Document Title	Date	Revision
RtS 4 Supplementary Response Drawing Change Register	03/05/2019	01

Concept Proposal - Change Register

SSD2 Stage 1 DA Drawings - Change Register**AR-SKE-10-110 – Revision 03**

AR-SKE-10-007

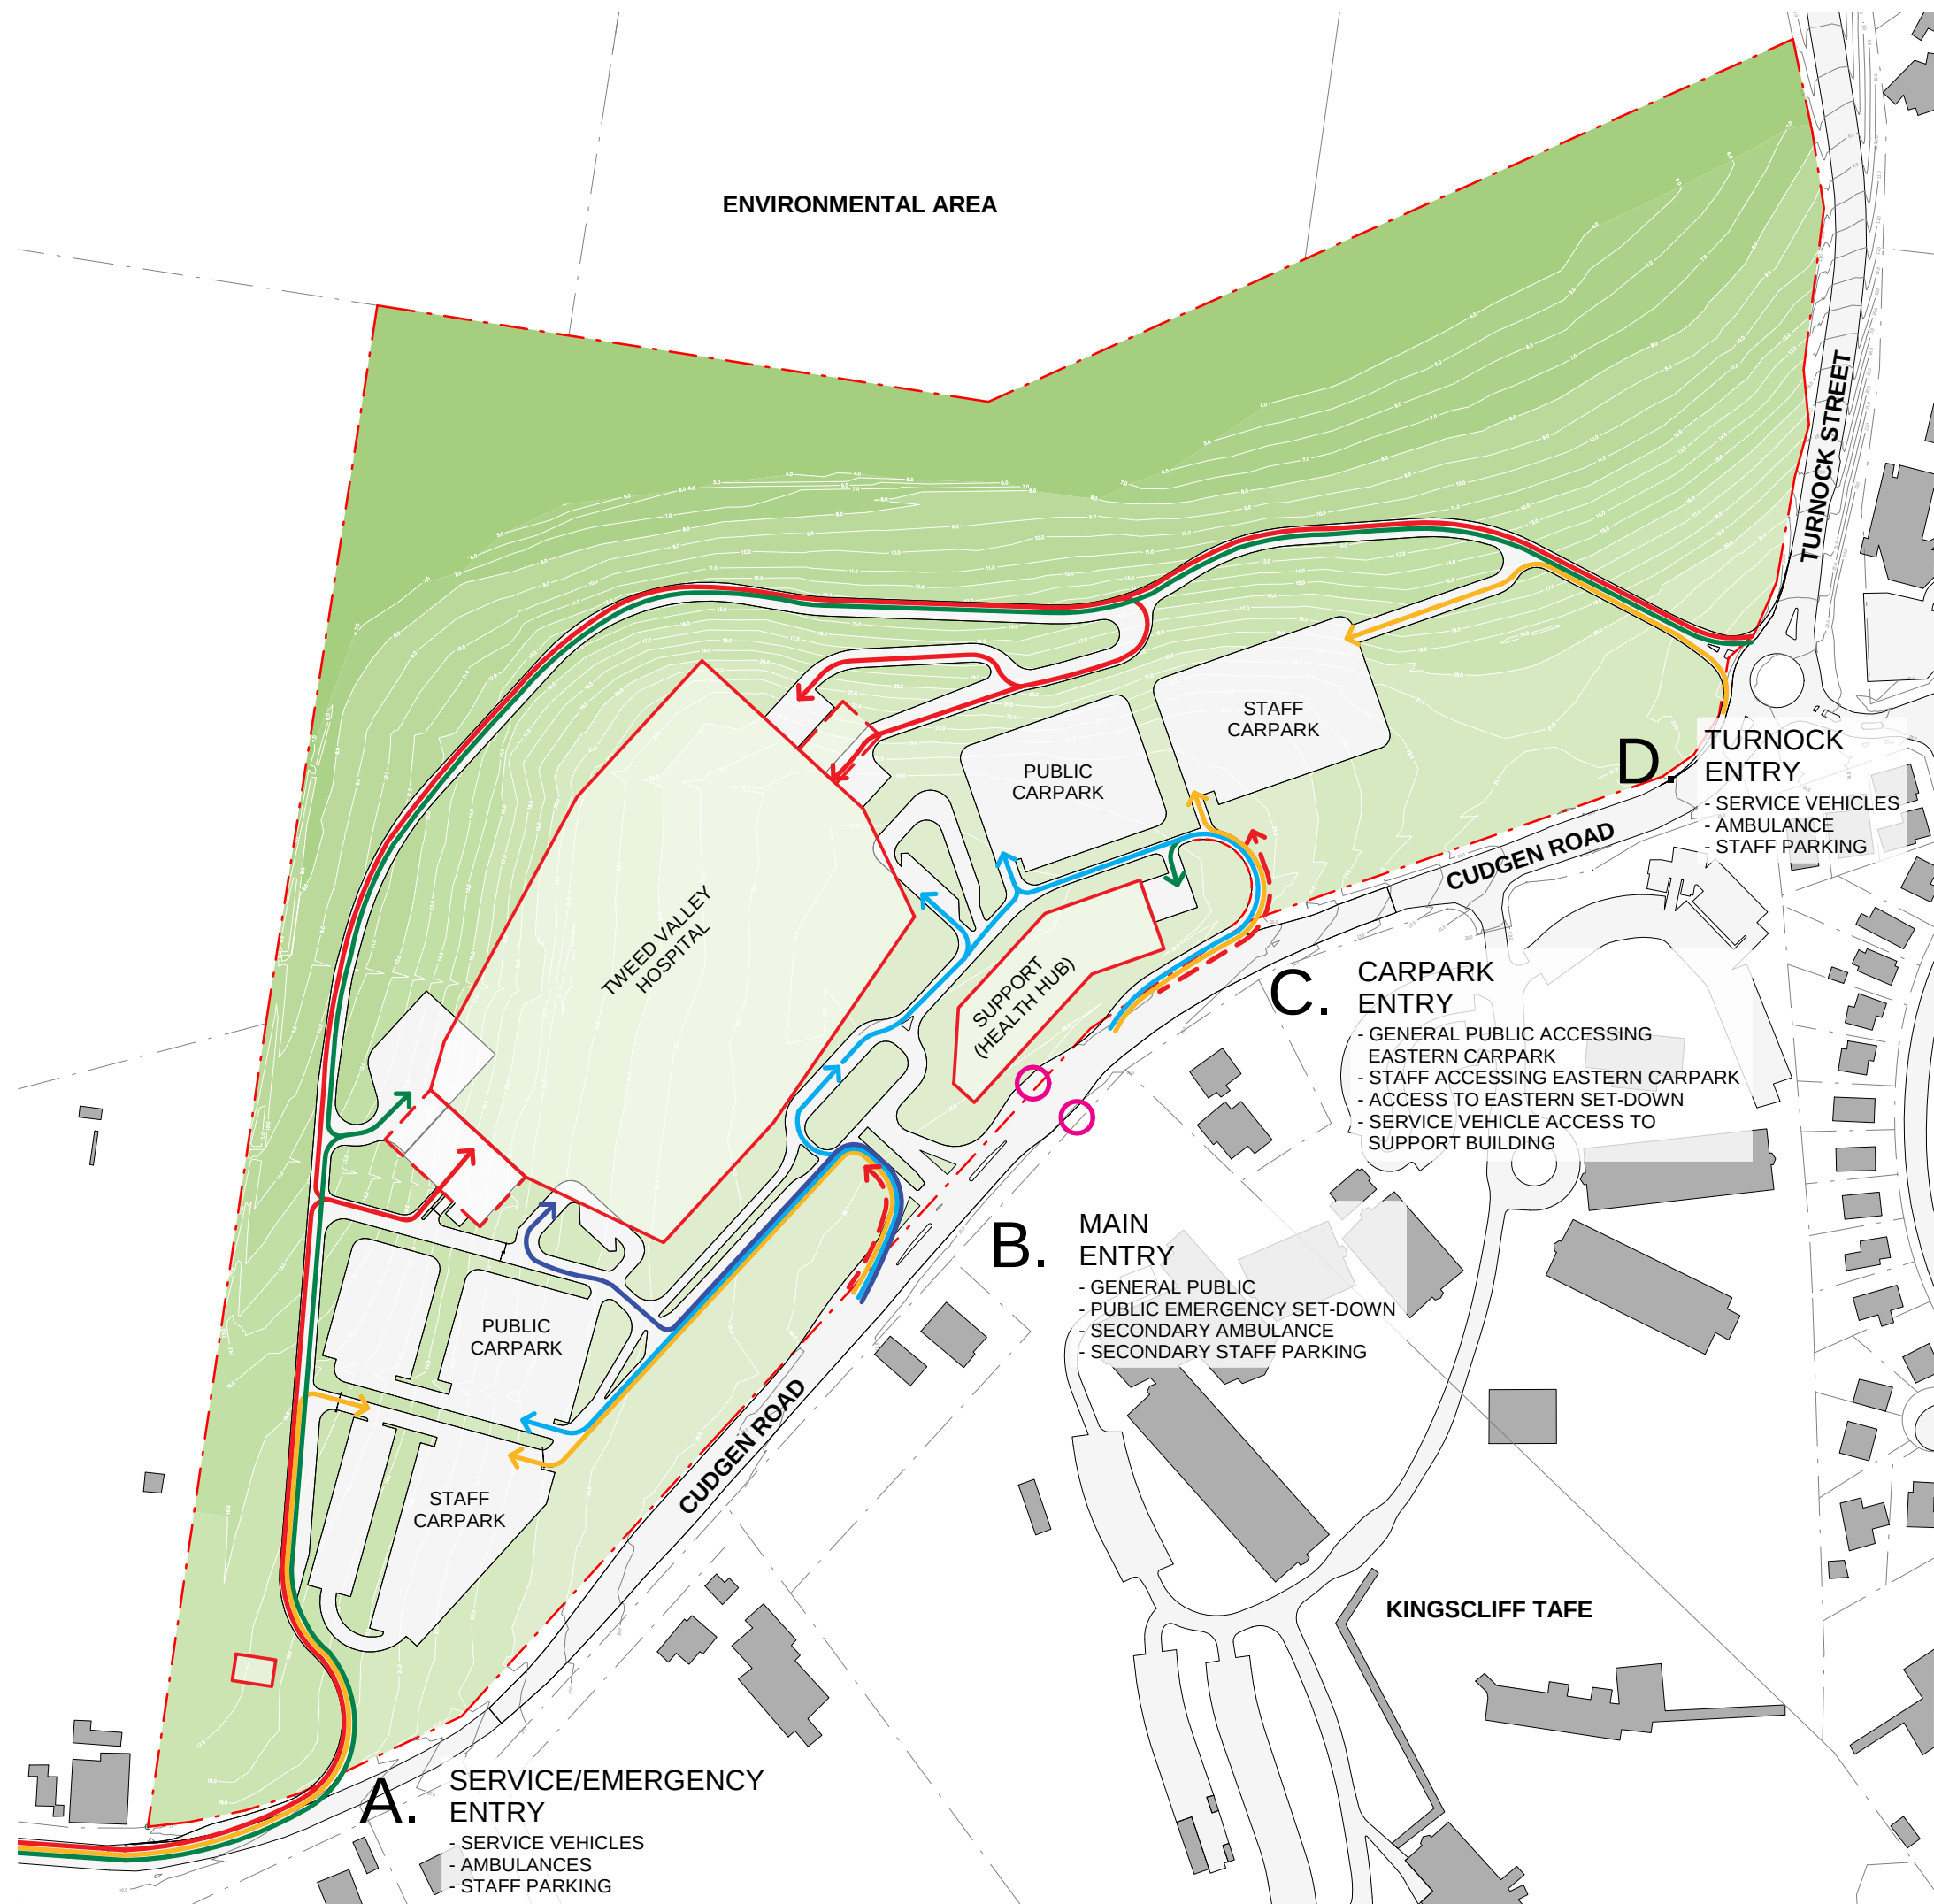
- Maximum Planning Envelope (MPE) location and geometry revised
- Roads/Carparks updated to reflect revised location and geometry of MPE
- Minor updates to Access arrows to reflect revised roads/carparks

AR-SKE-10-009

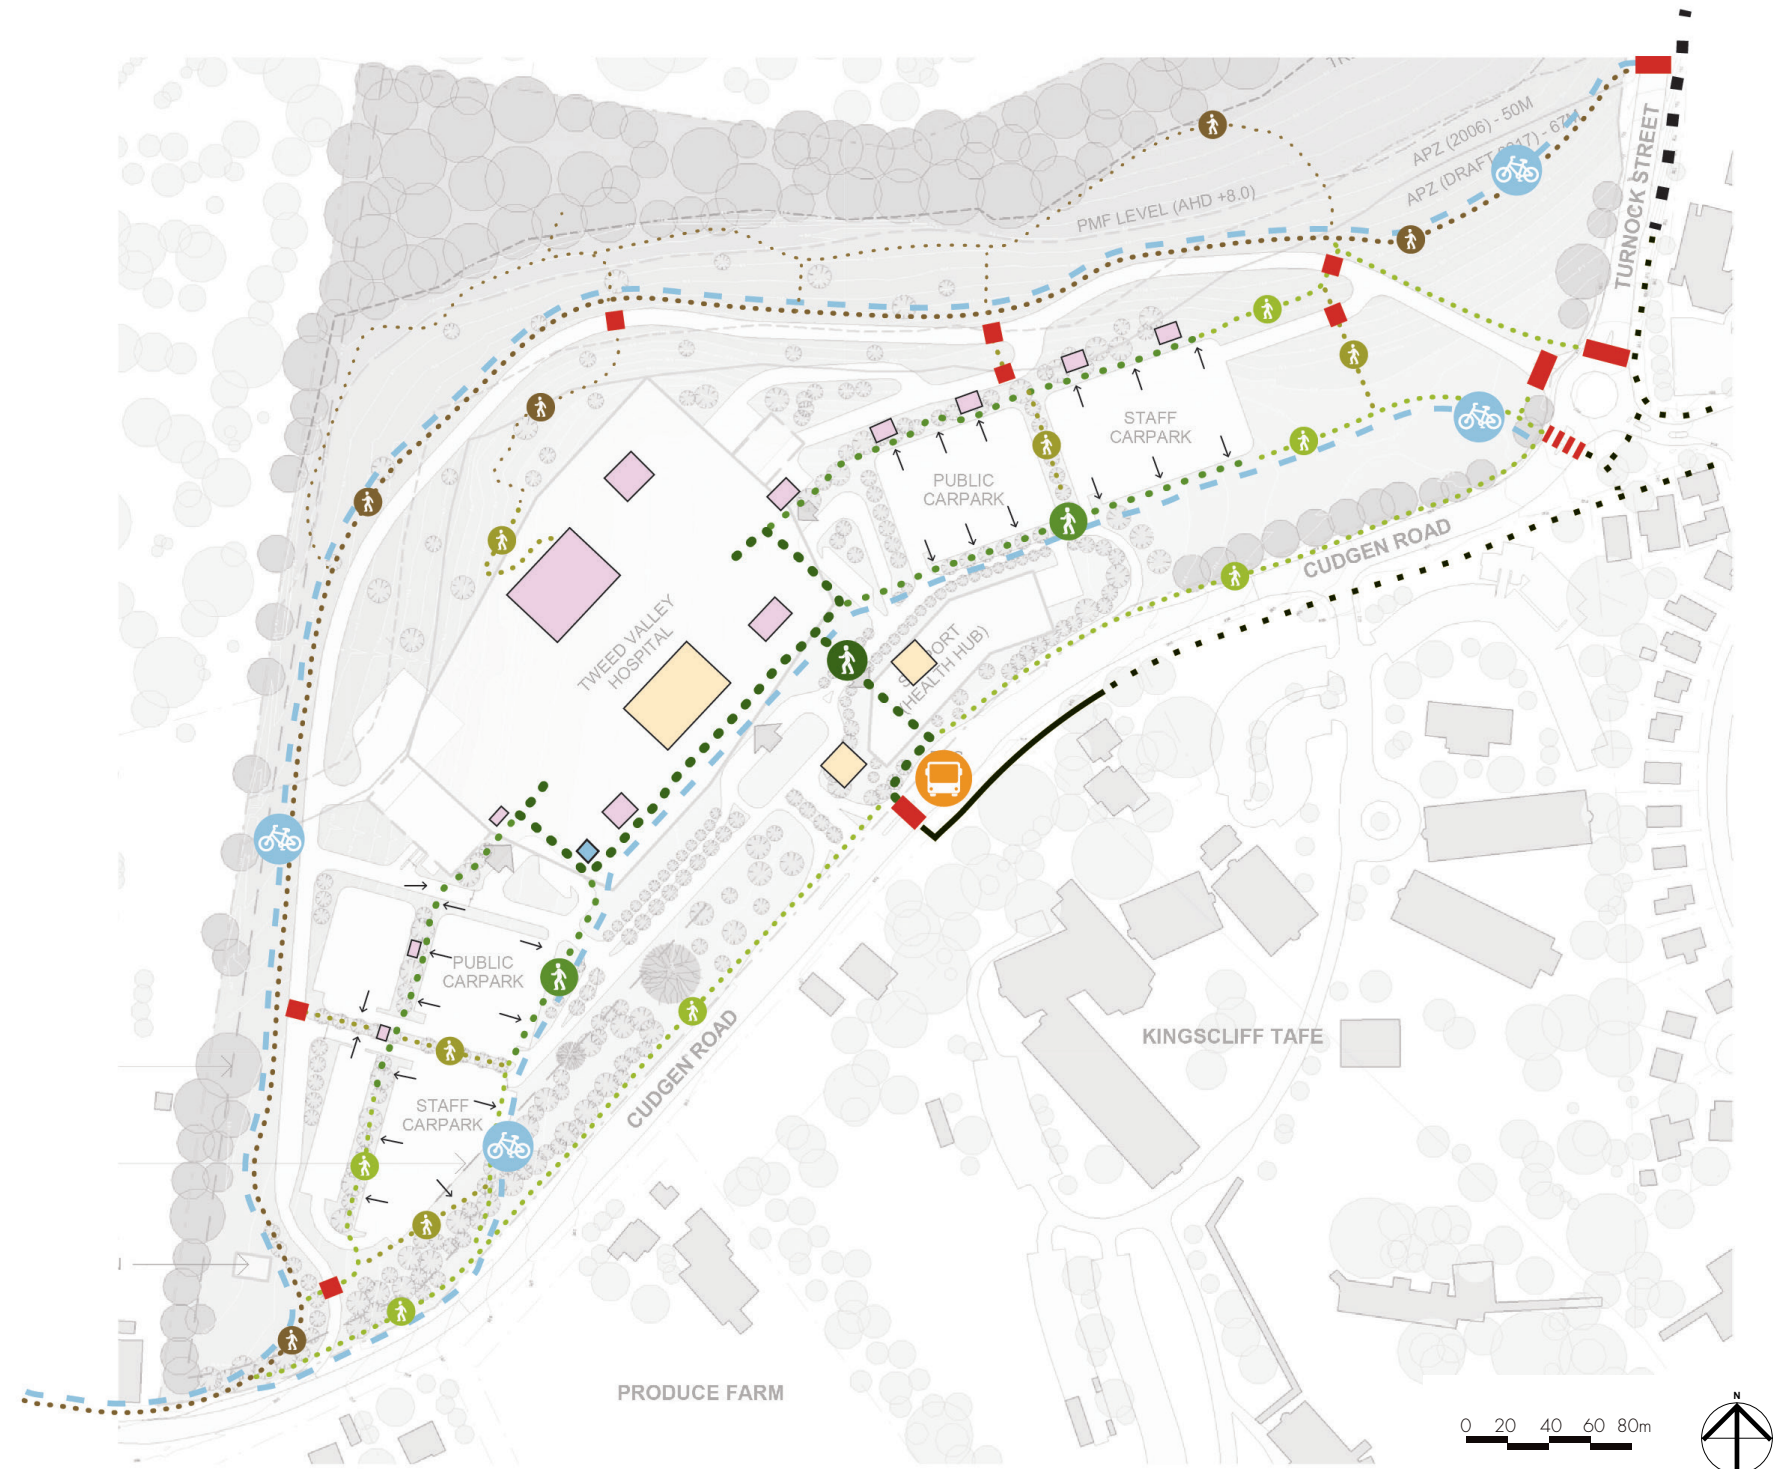
- Maximum Planning Envelope (MPE) location and geometry revised
- Roads/Carparks updated to reflect revised location and geometry of MPE
- Existing AHDs at corners of MPE updated to reflect revised location and geometry

AR-SKE-50-101

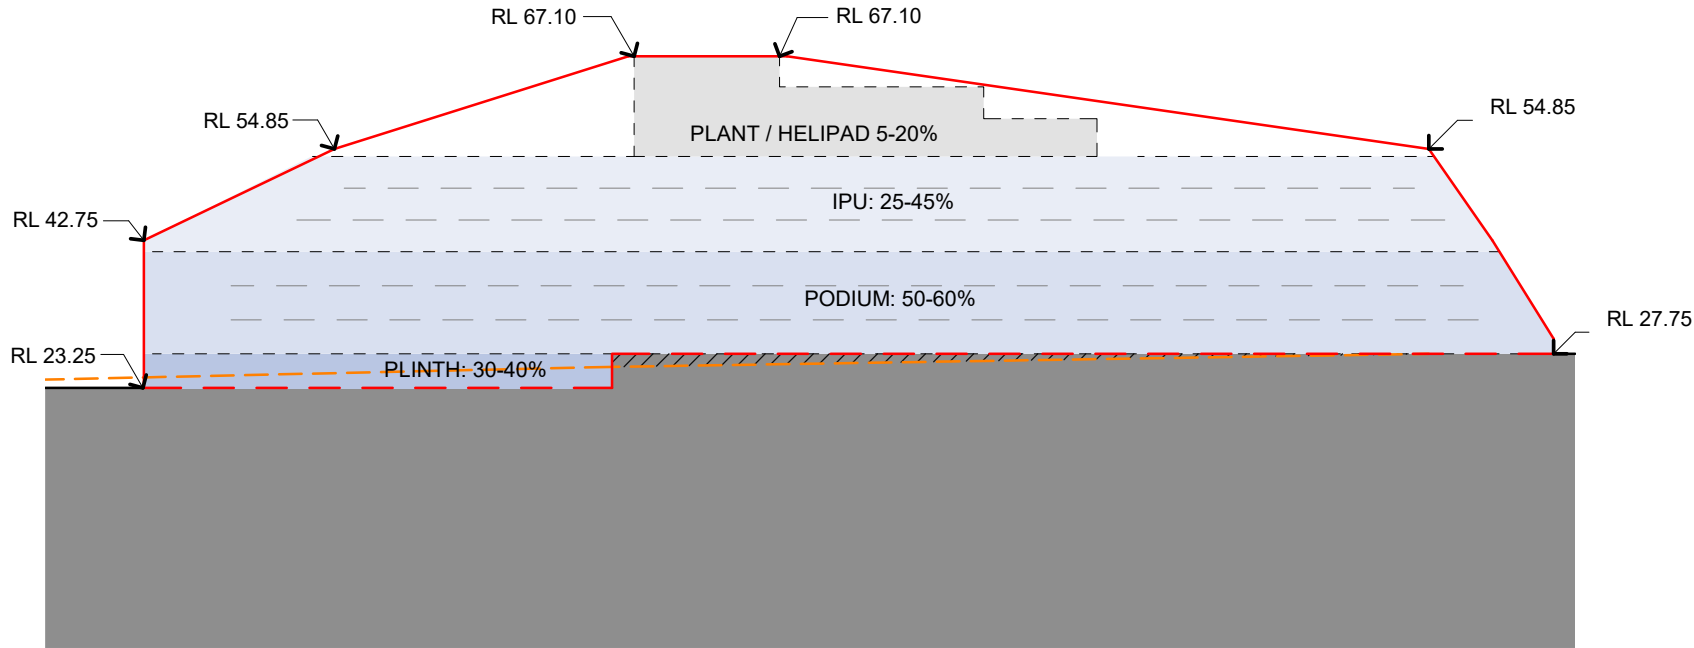
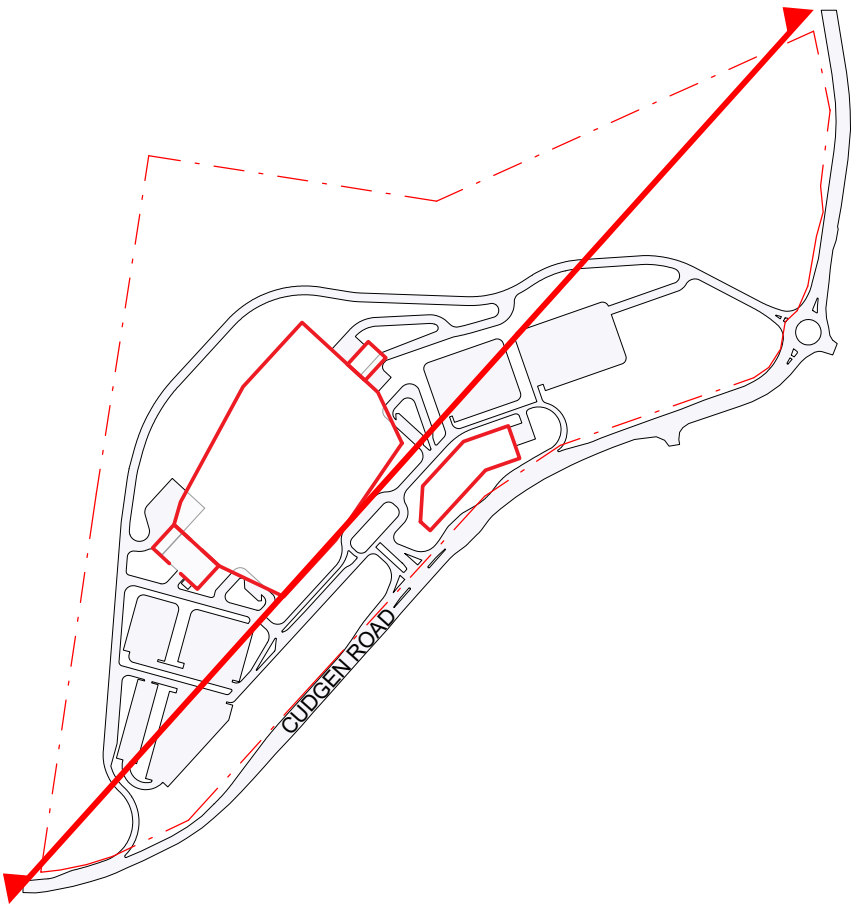
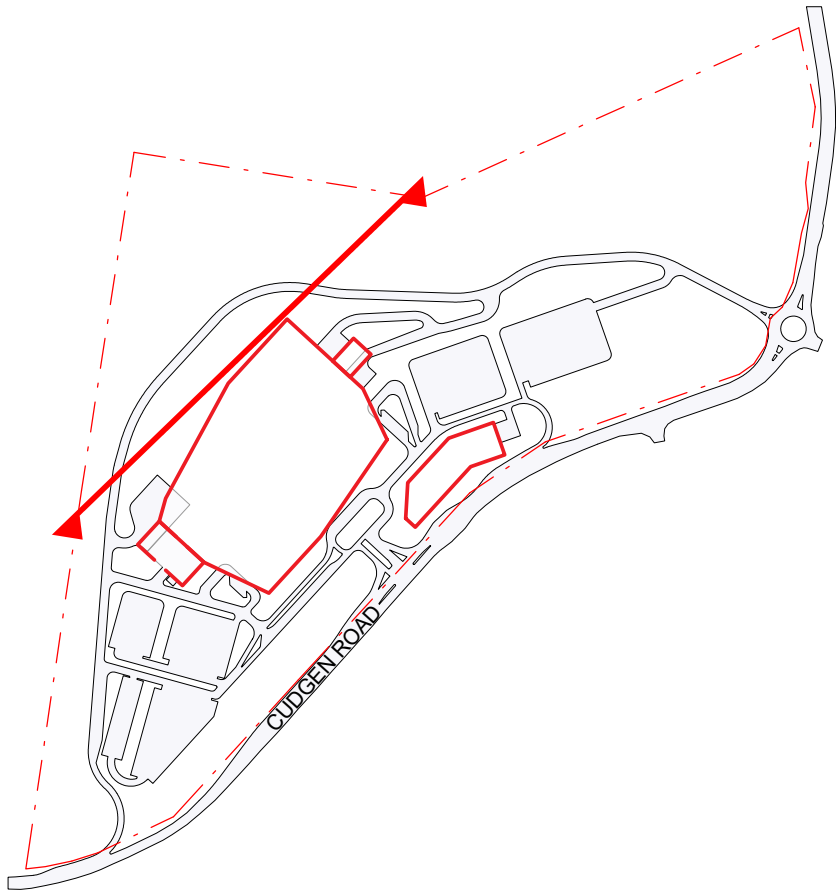
- Maximum Planning Envelope (MPE) location and geometry revised
- Additional RL 42.75 added
- Key Plan updated

AR-SKE-50-201

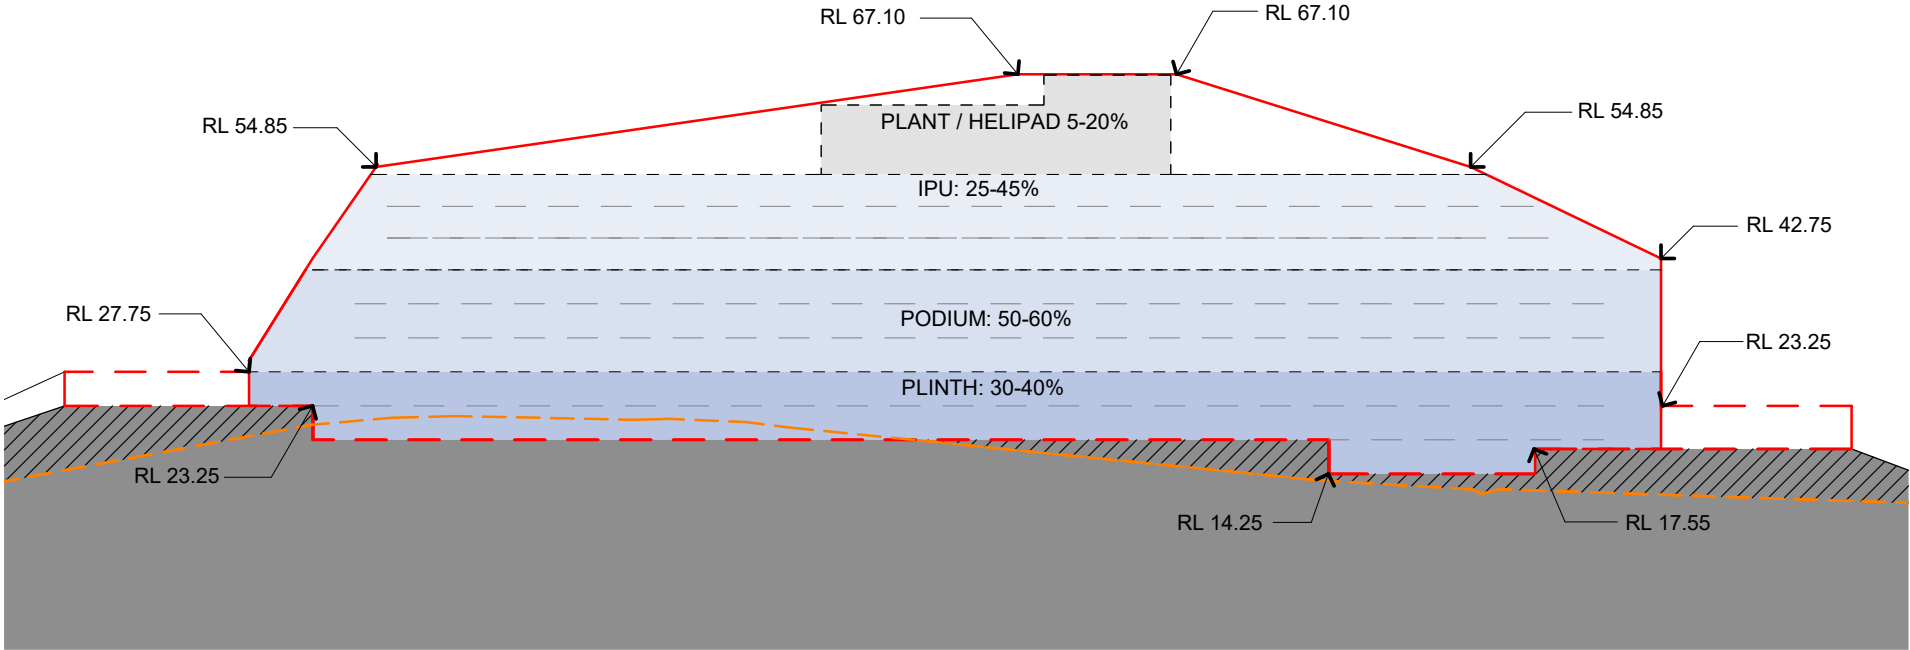
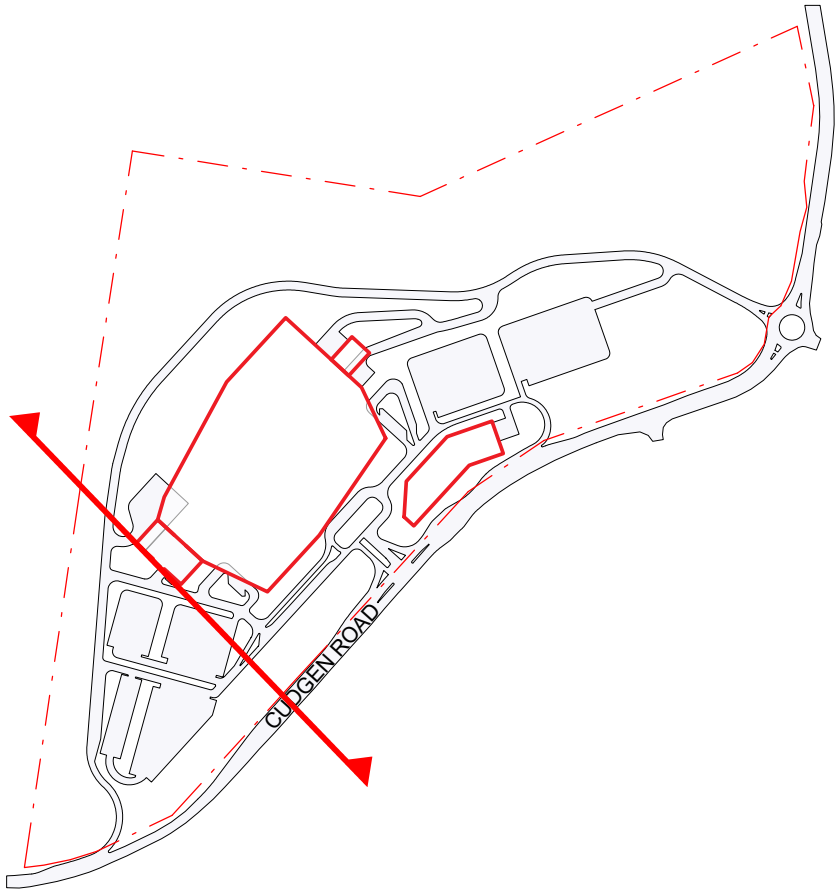
- Maximum Planning Envelope (MPE) location and geometry revised
- Additional RL 42.75 added
- Key Plan updated
